SUBJECT: Engineering Review Comment
Mountain View Electric Association Inc. (MVEA)

Project Name: Sterling Ranch Filing 3A – Replat of Tract C, Sterling Ranch Filing 3
Project Number: SF2413
Description: Proposed development of 3 residential lots located on Pennydale Dr. south of Sterling Ranch Dr. in Township 12S, Range 65W, Section 33.

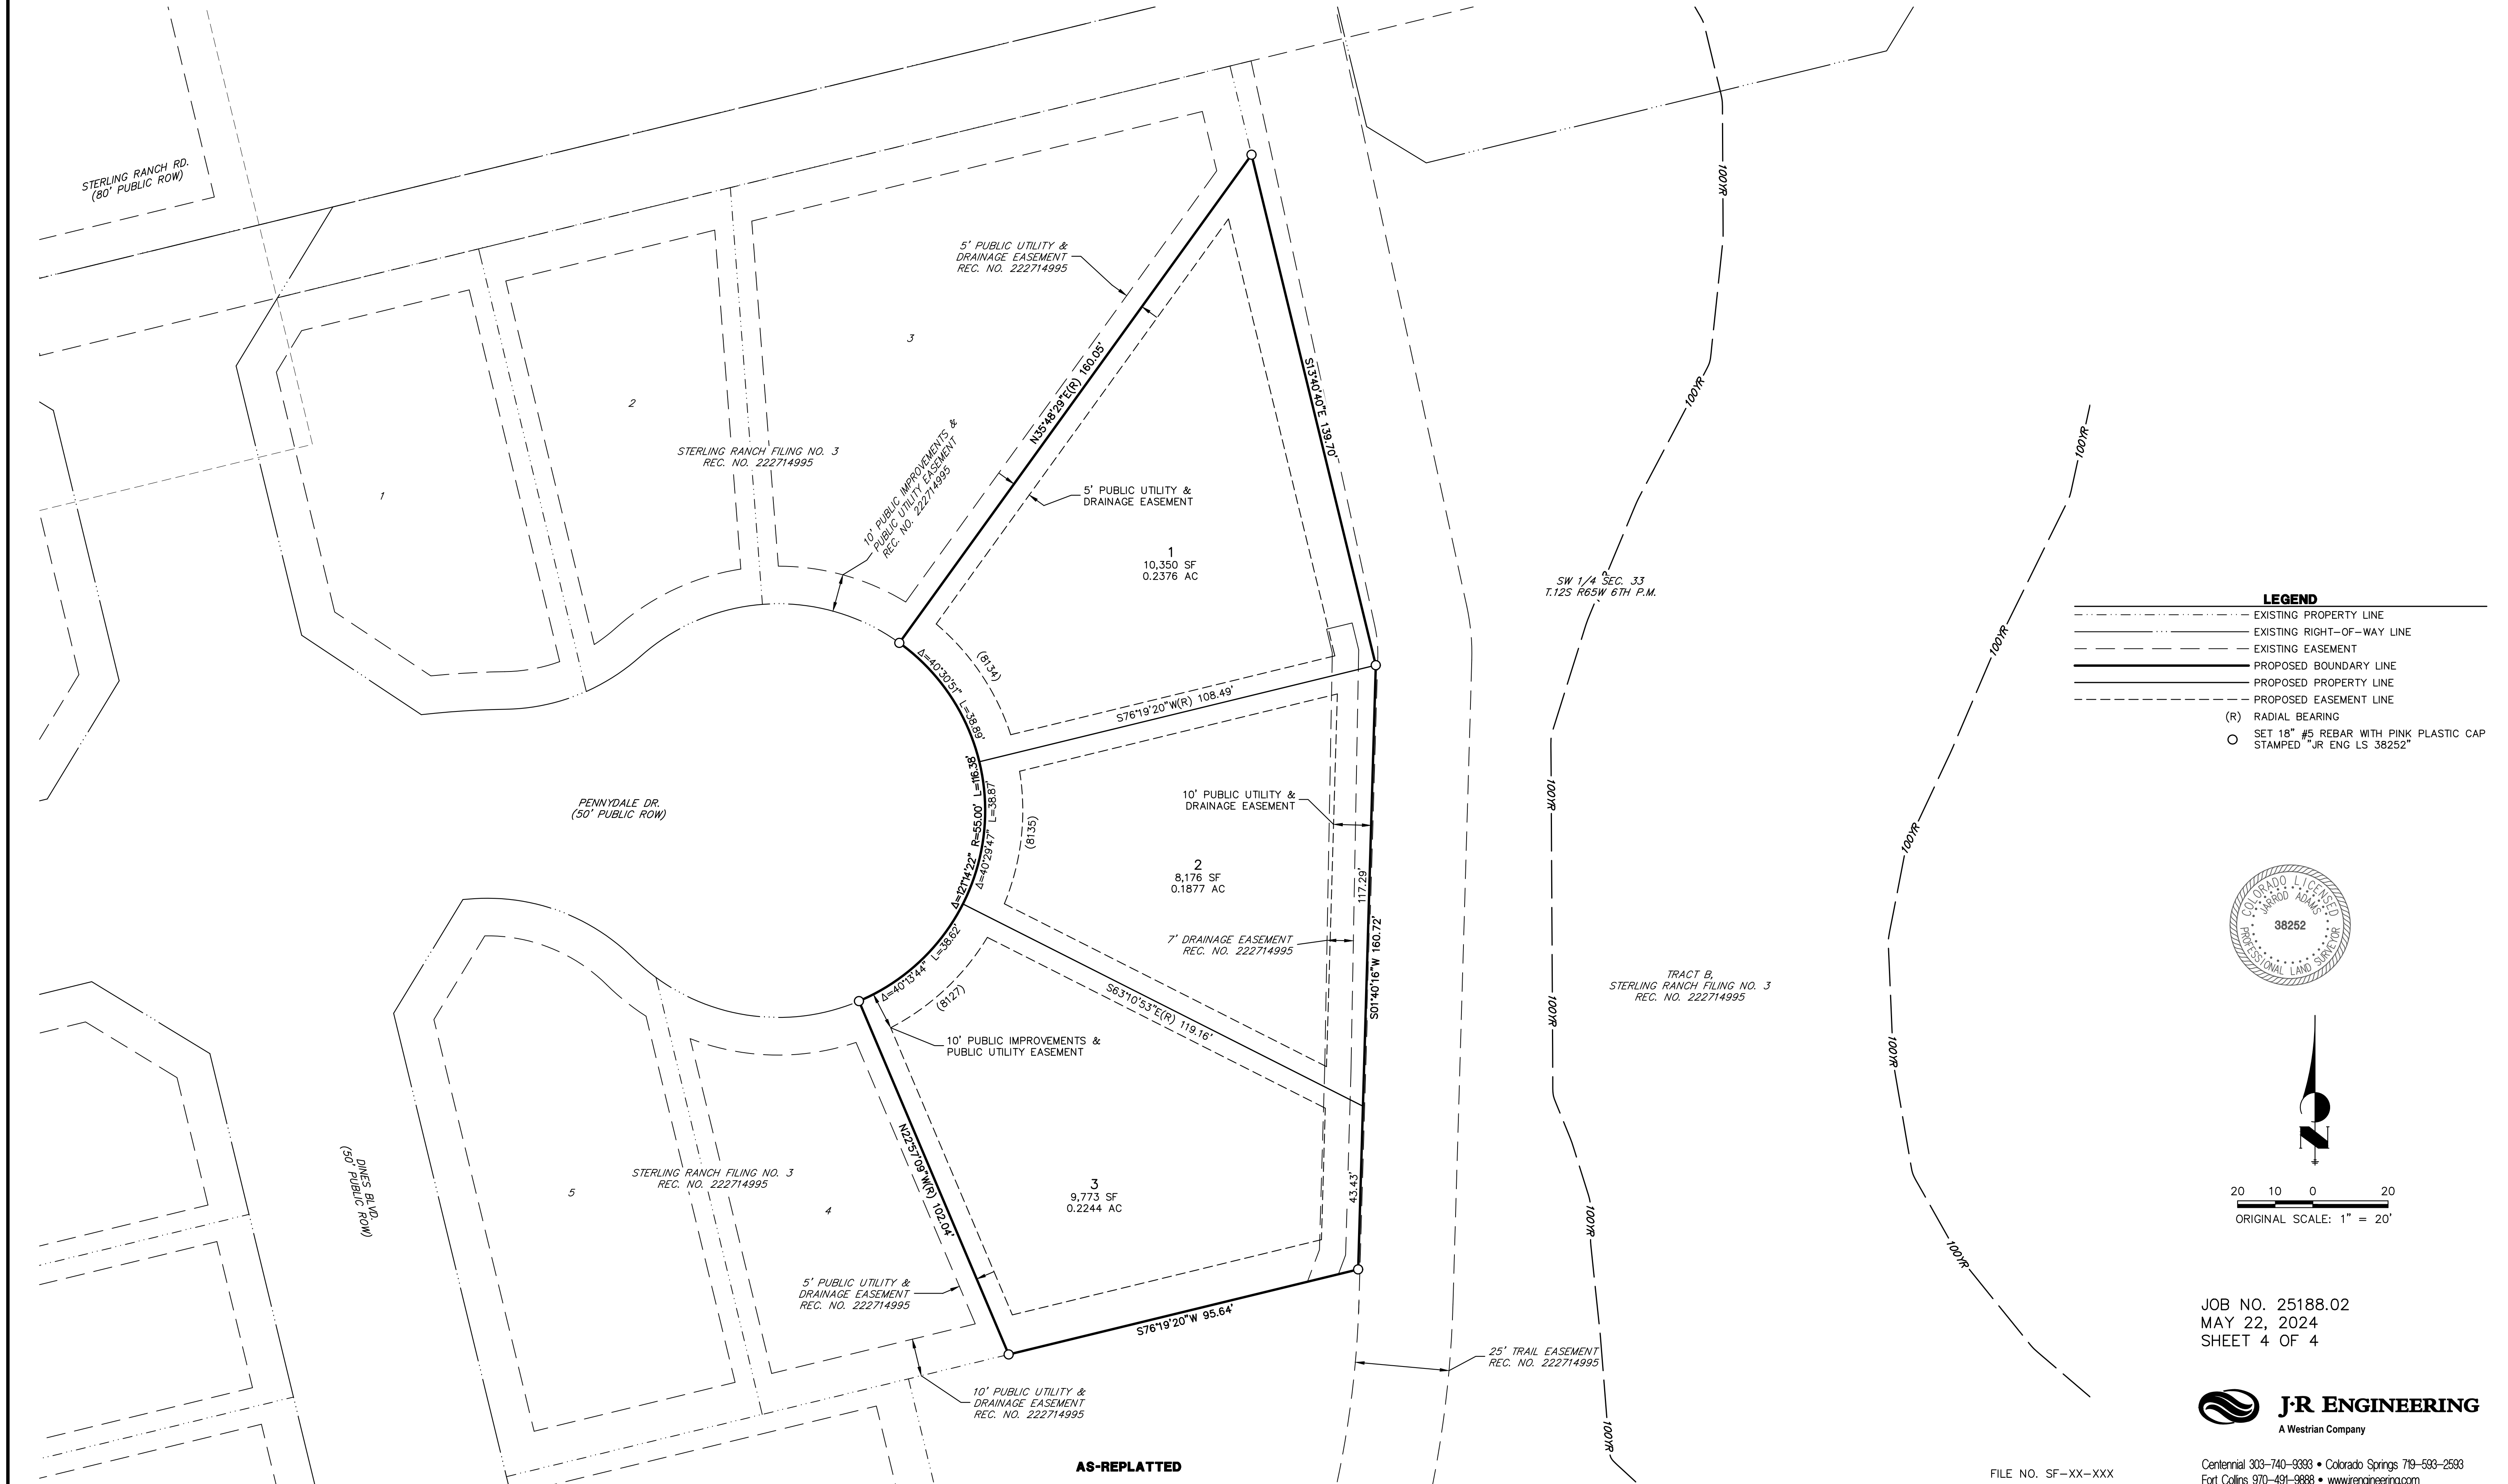
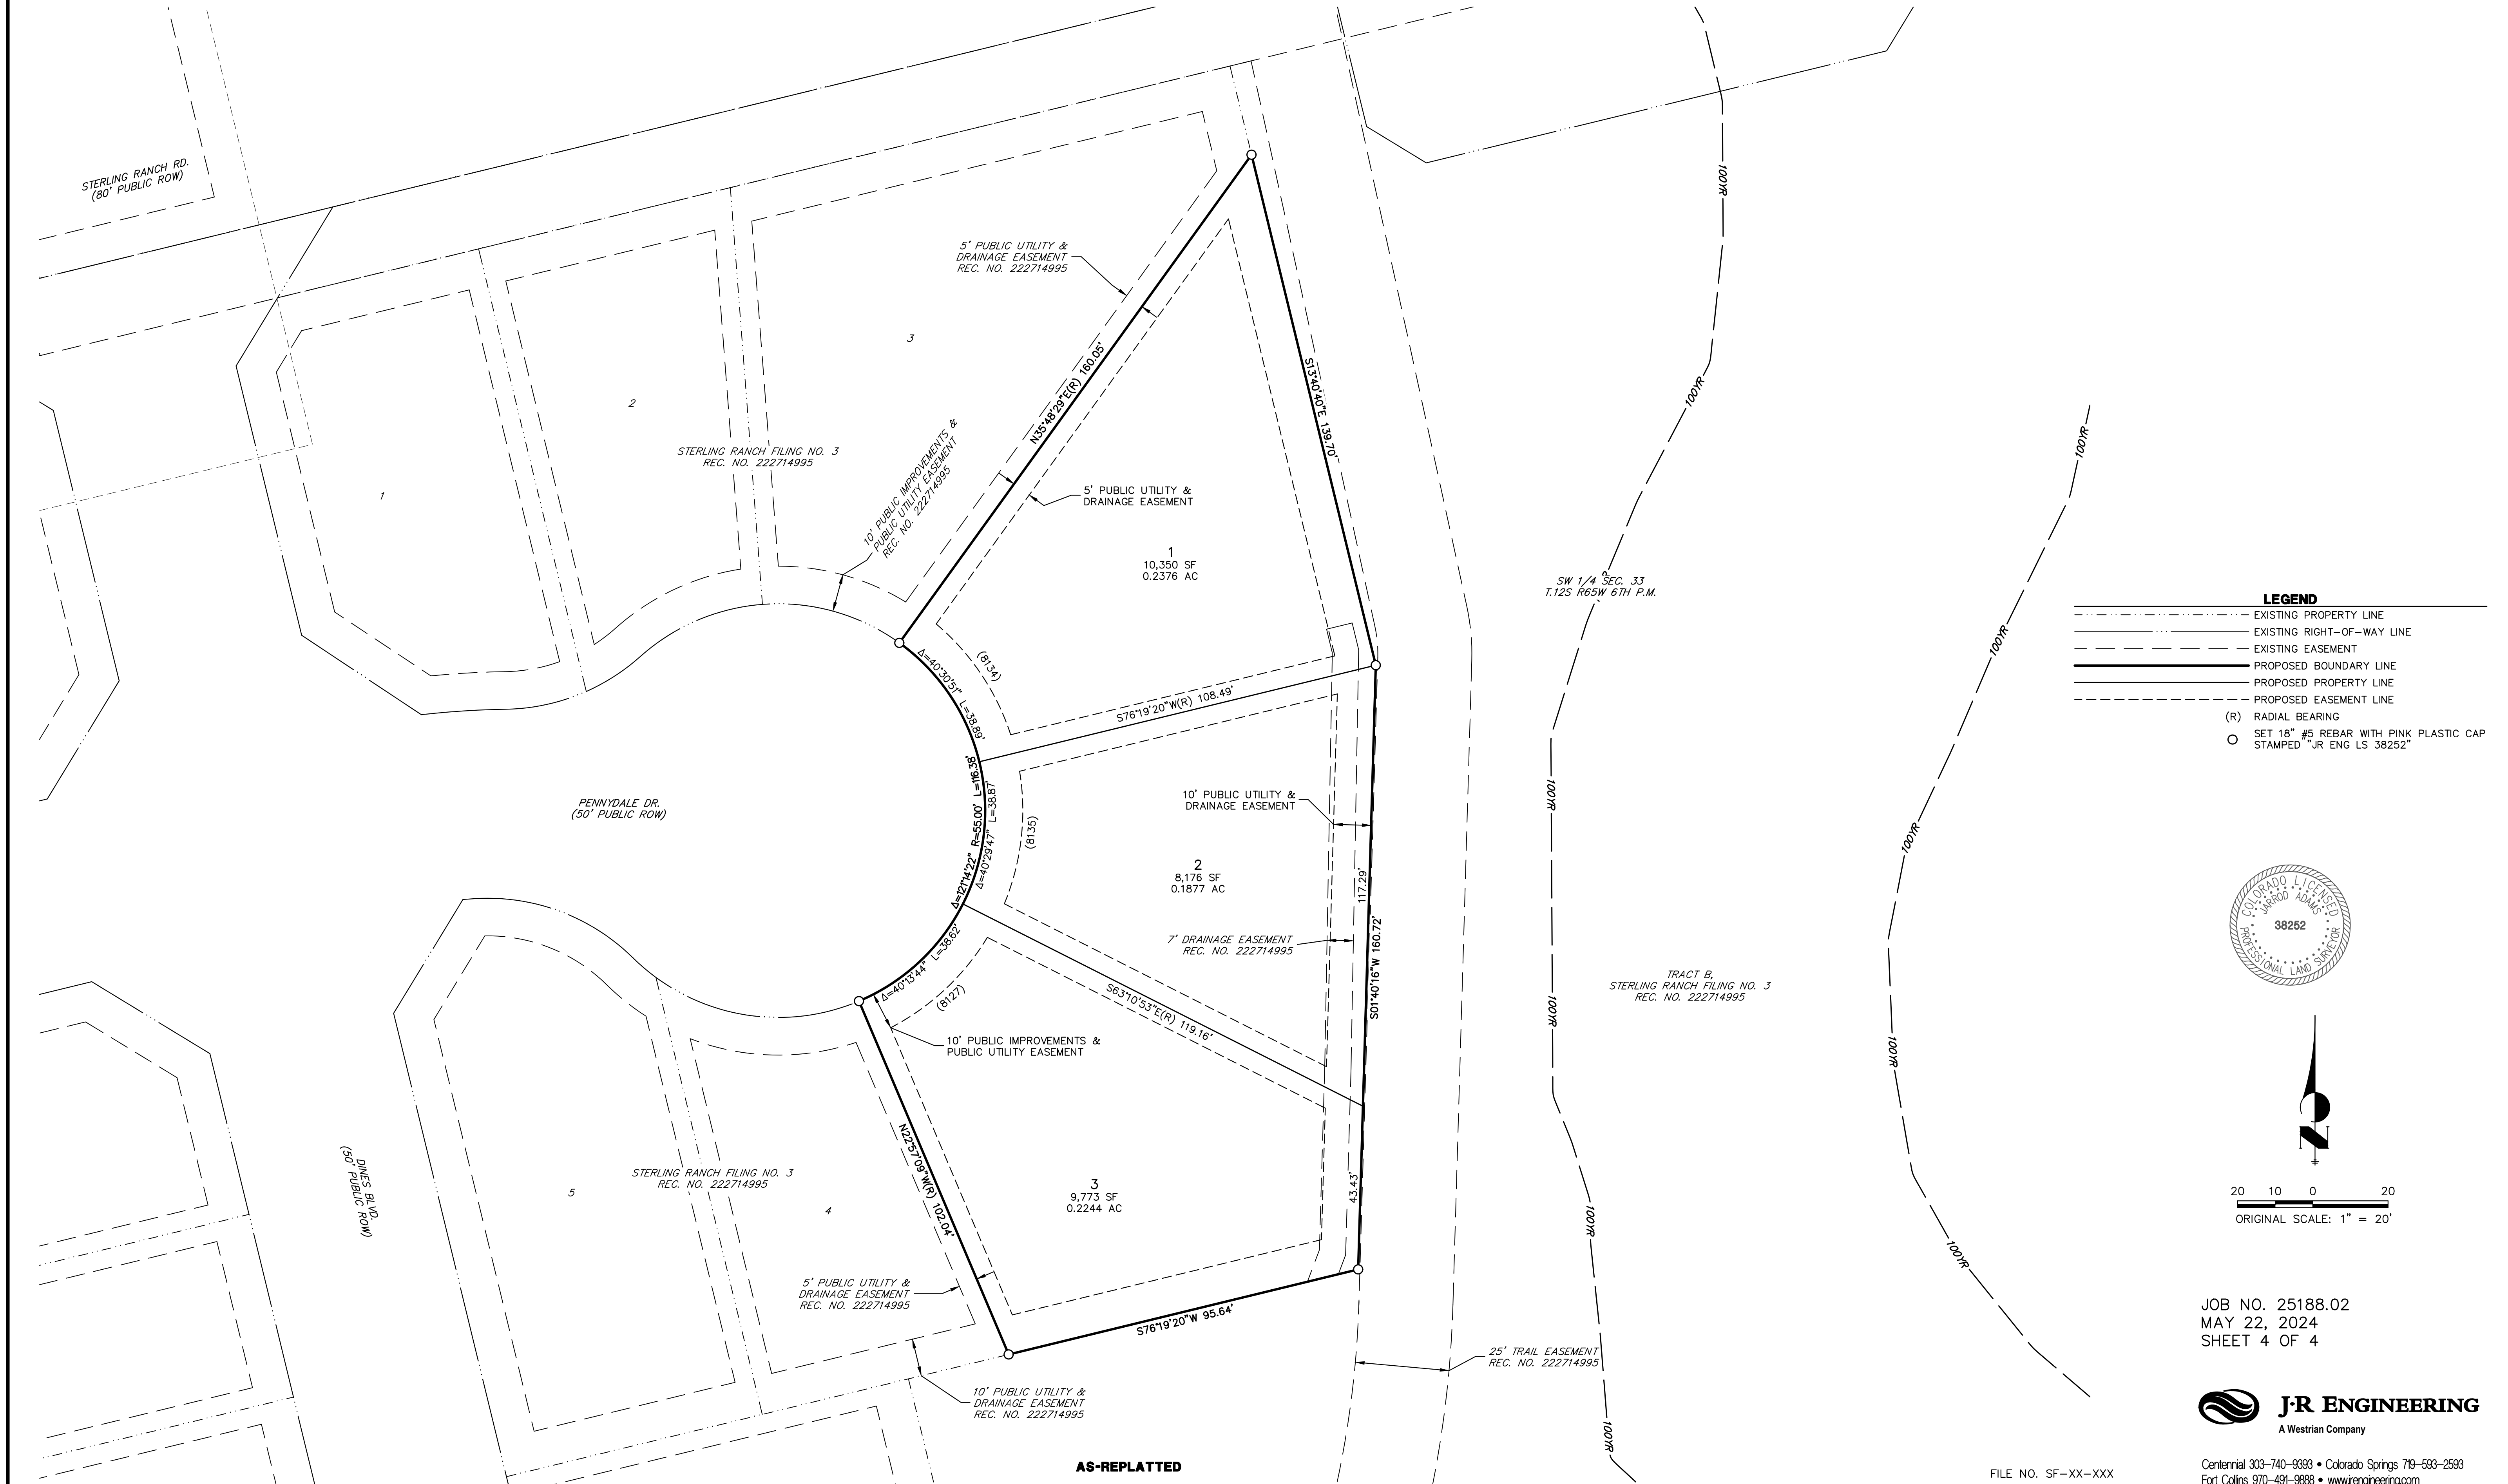
MVEA requests a ten (10) foot front lot utility easement in addition to any public improvement easement, a five (5) foot side lot utility easement, and a ten (10) foot rear lot utility easement along with a twenty (20) foot exterior utility easement on the plat and all tracts include easements. MVEA also requests the platting of MVEA's existing facilities with easements on the plat. Additional easements may be required.
